Phone: 0300 123 6780
Email: Kathryn.Walsh@lancashire.gov.uk
Your ref: 3/2024/0969
Our ref: 3/2024/0969/HDC/KW
Date: 28 February 2025

Location: 24 Durham Road Wilpshire BB1 9LR
Proposal: Proposed change of use of conservatory to commercial art studio and pottery for producing, stocking, selling online and teaching small groups (up to 4 at a time) three times per week.
Grid Ref: 369008 433108

Client: Marion Walsh		
Project: Proposed Alterations 24 Dunham Road Wiltshire		
Dwg title: Proposed Site Plan		
Scale @ A4: 1:200	Date: 04.12.24	Drawn by: PD
Drawing no. 1682 - 102		Rev. C

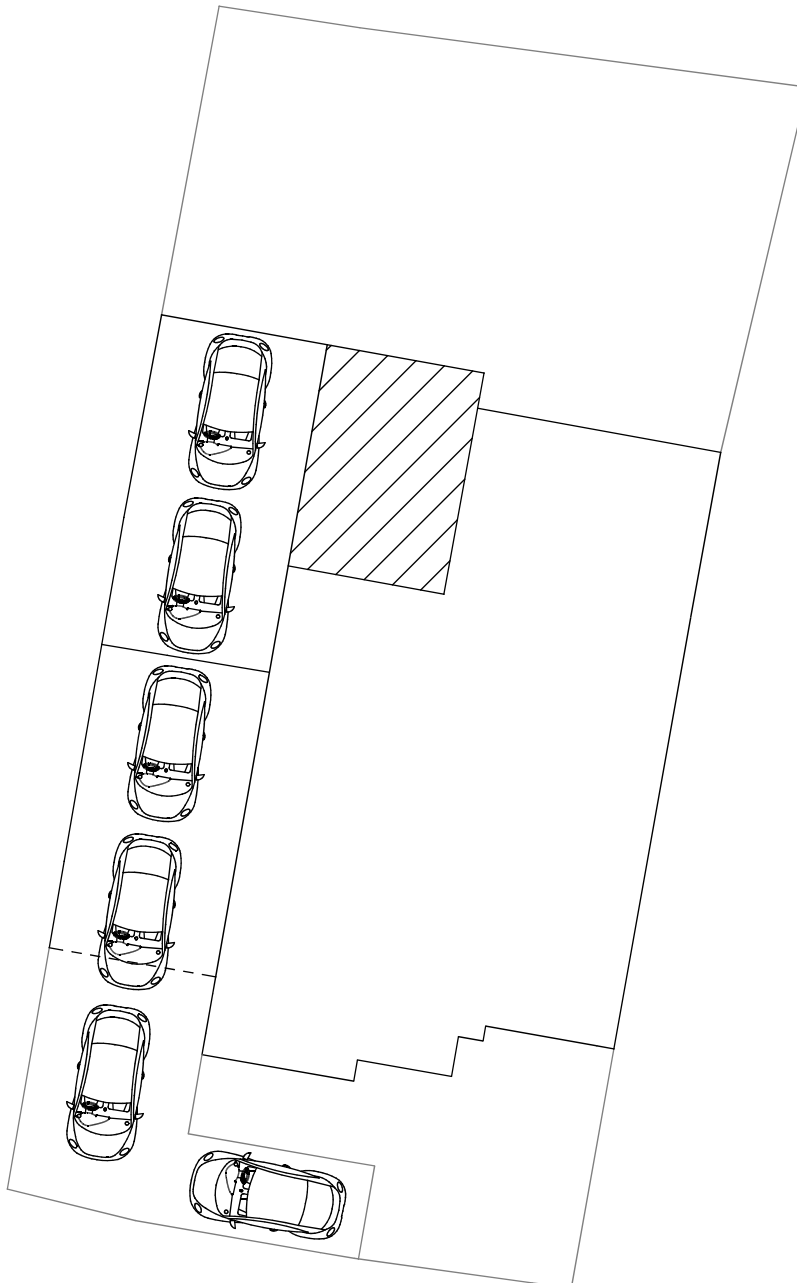
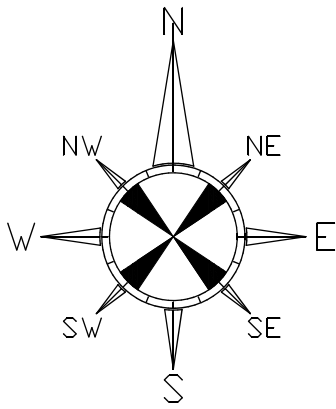
The LHA have previously raised concerns regarding the parking provisions within the site, however, the applicant has since amended the application to reduce the number of clients in attendance to 4 and amended the area in which sessions will take place to retain a section of off-street parking provisions which has addressed the LHAs concerns as such, the effect of the development on the operation of the local highway network would be negligible.

1. A minimum of 2 car parking spaces shall thereafter be kept available for the parking of attendees' vehicles associated with the art and pottery business for the lifetime of the development.
Reason: To ensure the provision of adequate car parking on site and in the interests of highway safety.

3. A minimum of 15 minutes shall be provided between each session to allow attendees to leave the parking area before the next session begins.
Reason: To ensure the provision of adequate car parking on-site and in the interests of highway safety.

5. The garage hereby approved shall be kept available for the parking of vehicles ancillary to the enjoyment of the household(s) and shall not be used for any use that would preclude the ability of their use for the parking of private motor vehicles, whether or not permitted by the provisions of the Town and Country Planning (General Permitted Development) Order 2015 or any order amending or revoking and re-enacting that order.
Reason: To ensure that adequate parking provision is retained on site.
